Our ref: DOC21/781602
Senders ref: SSD-11070211

Subject: EES comments on Environmental Impact Statement for New Public School in Mulgoa Rise – 1-23 Forestwood Drive, Glenmore Park – SSD-110702211

The Environment, Energy and Science Group (EES) has reviewed the following reports for this SSD:

1 CAR PARK PLAN 01
1 : 200

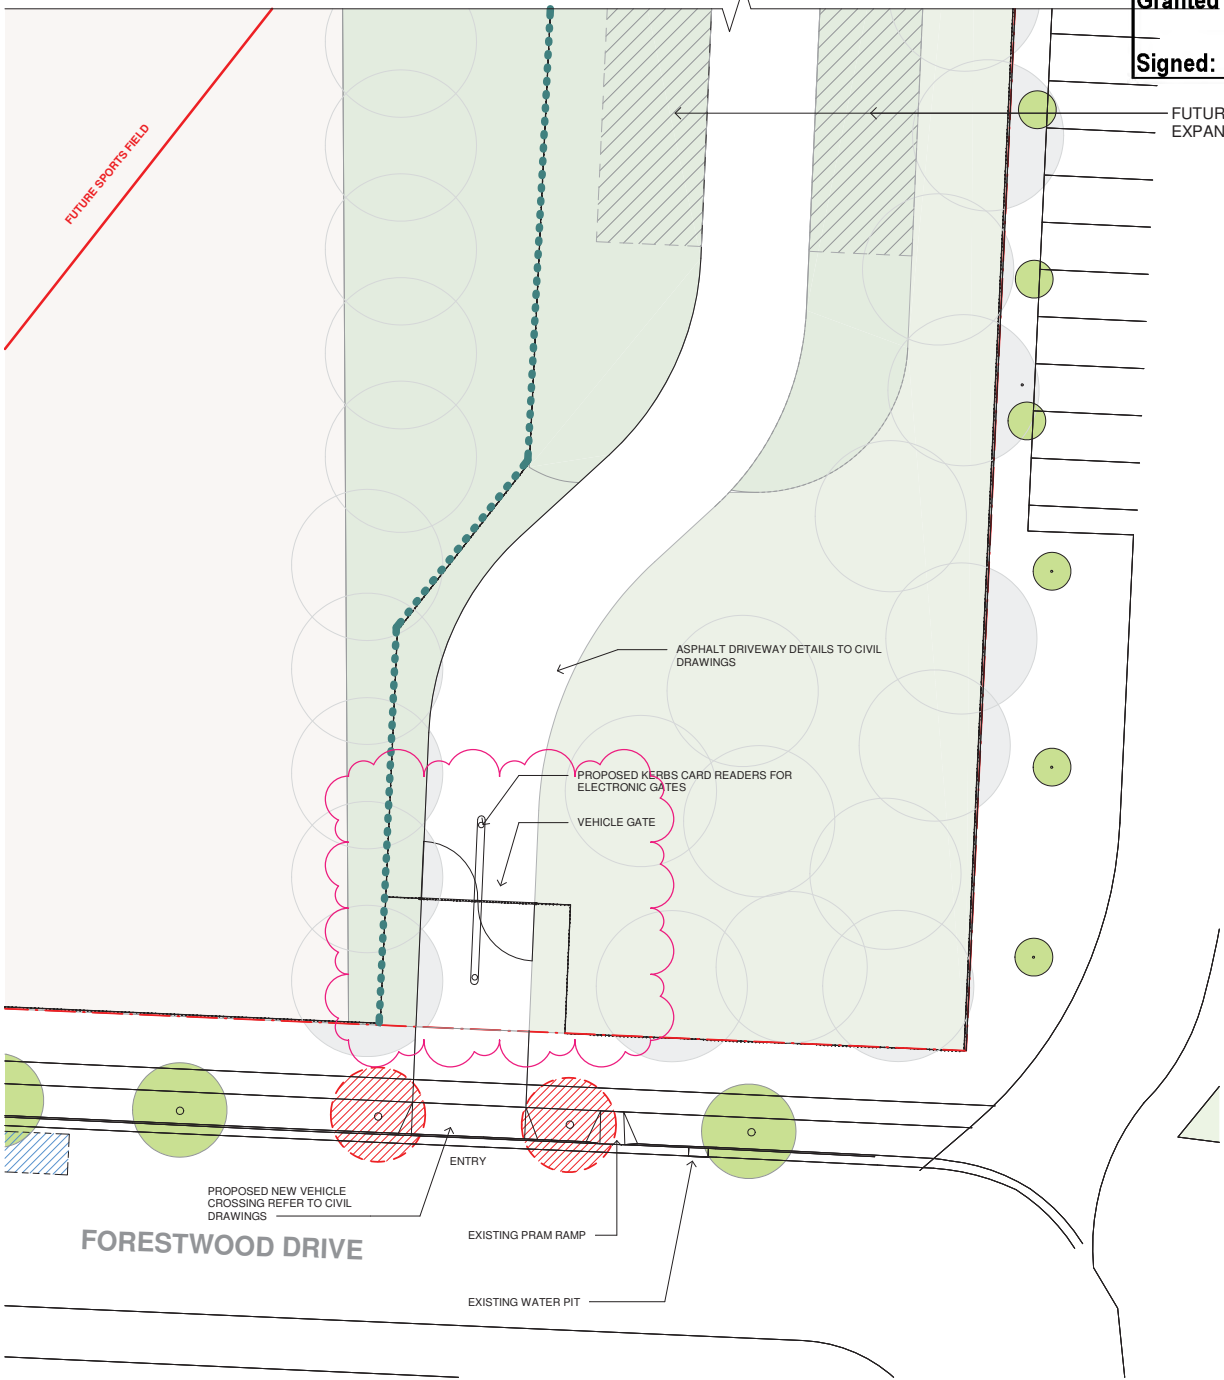
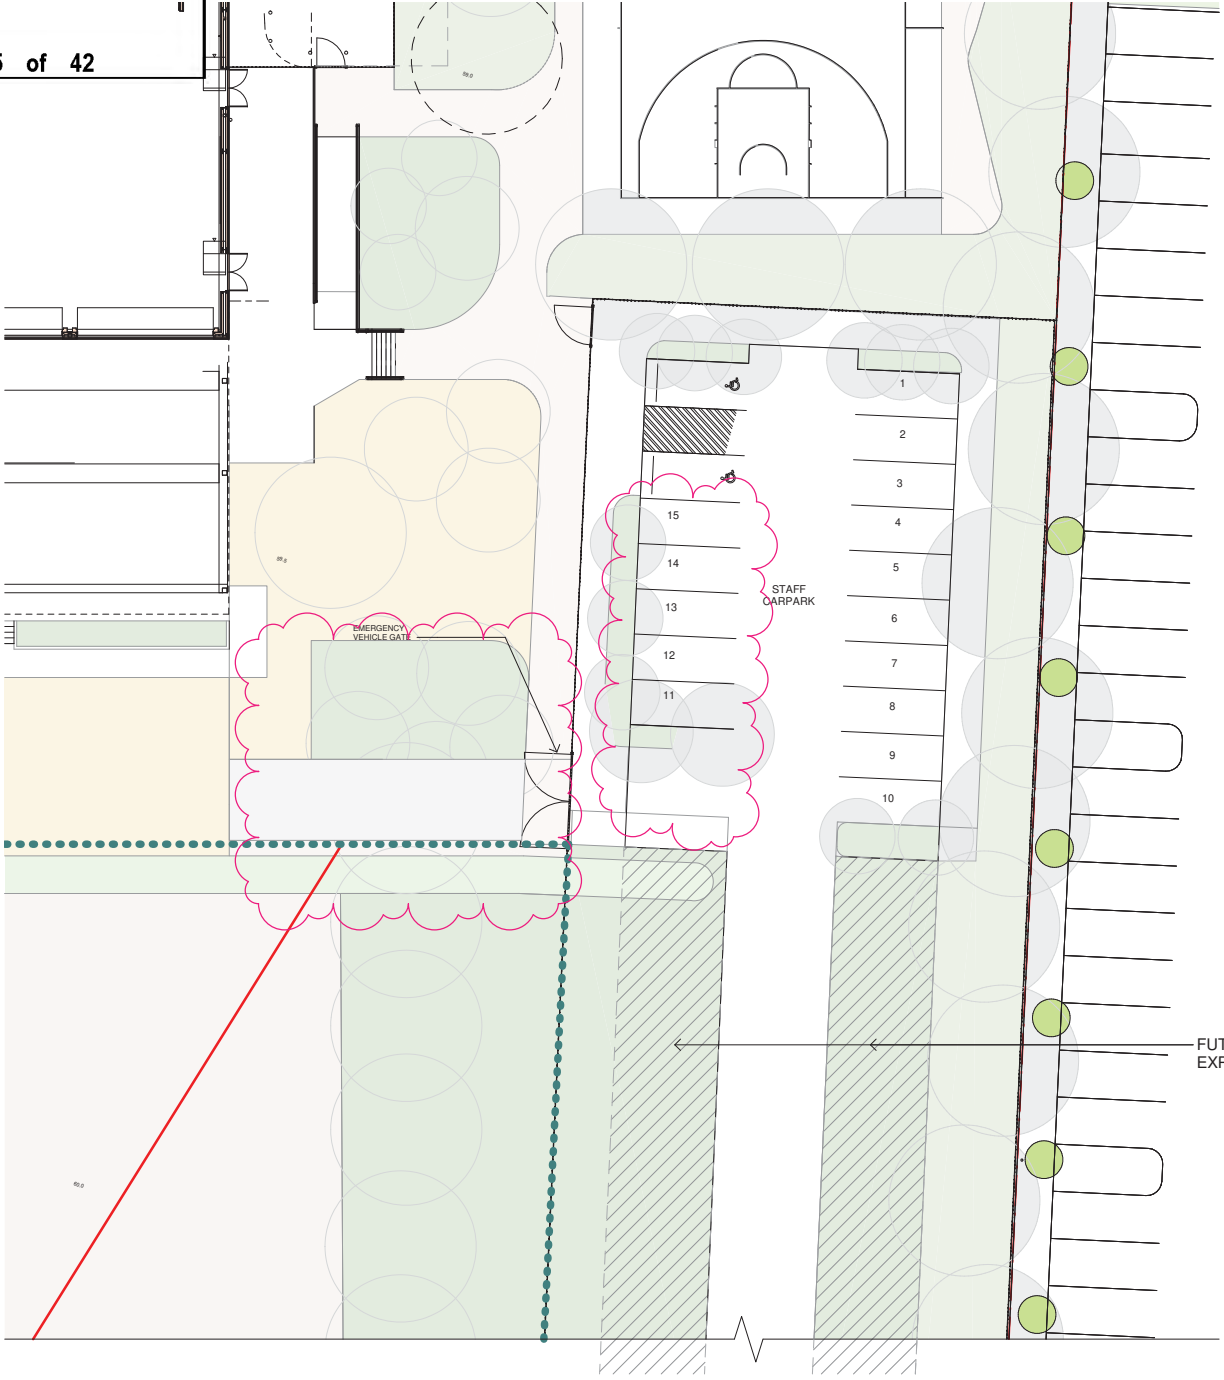
The Landscape Site Plan appears to show no tree planting is proposed within the staff carpark. The EIS notes for the carpark that vegetation utilised comprises low shrubs and high canopy planting (Table 9). EES recommends the carpark also incorporates planting of local native trees and groundcover species (Figure 14 in EIS).
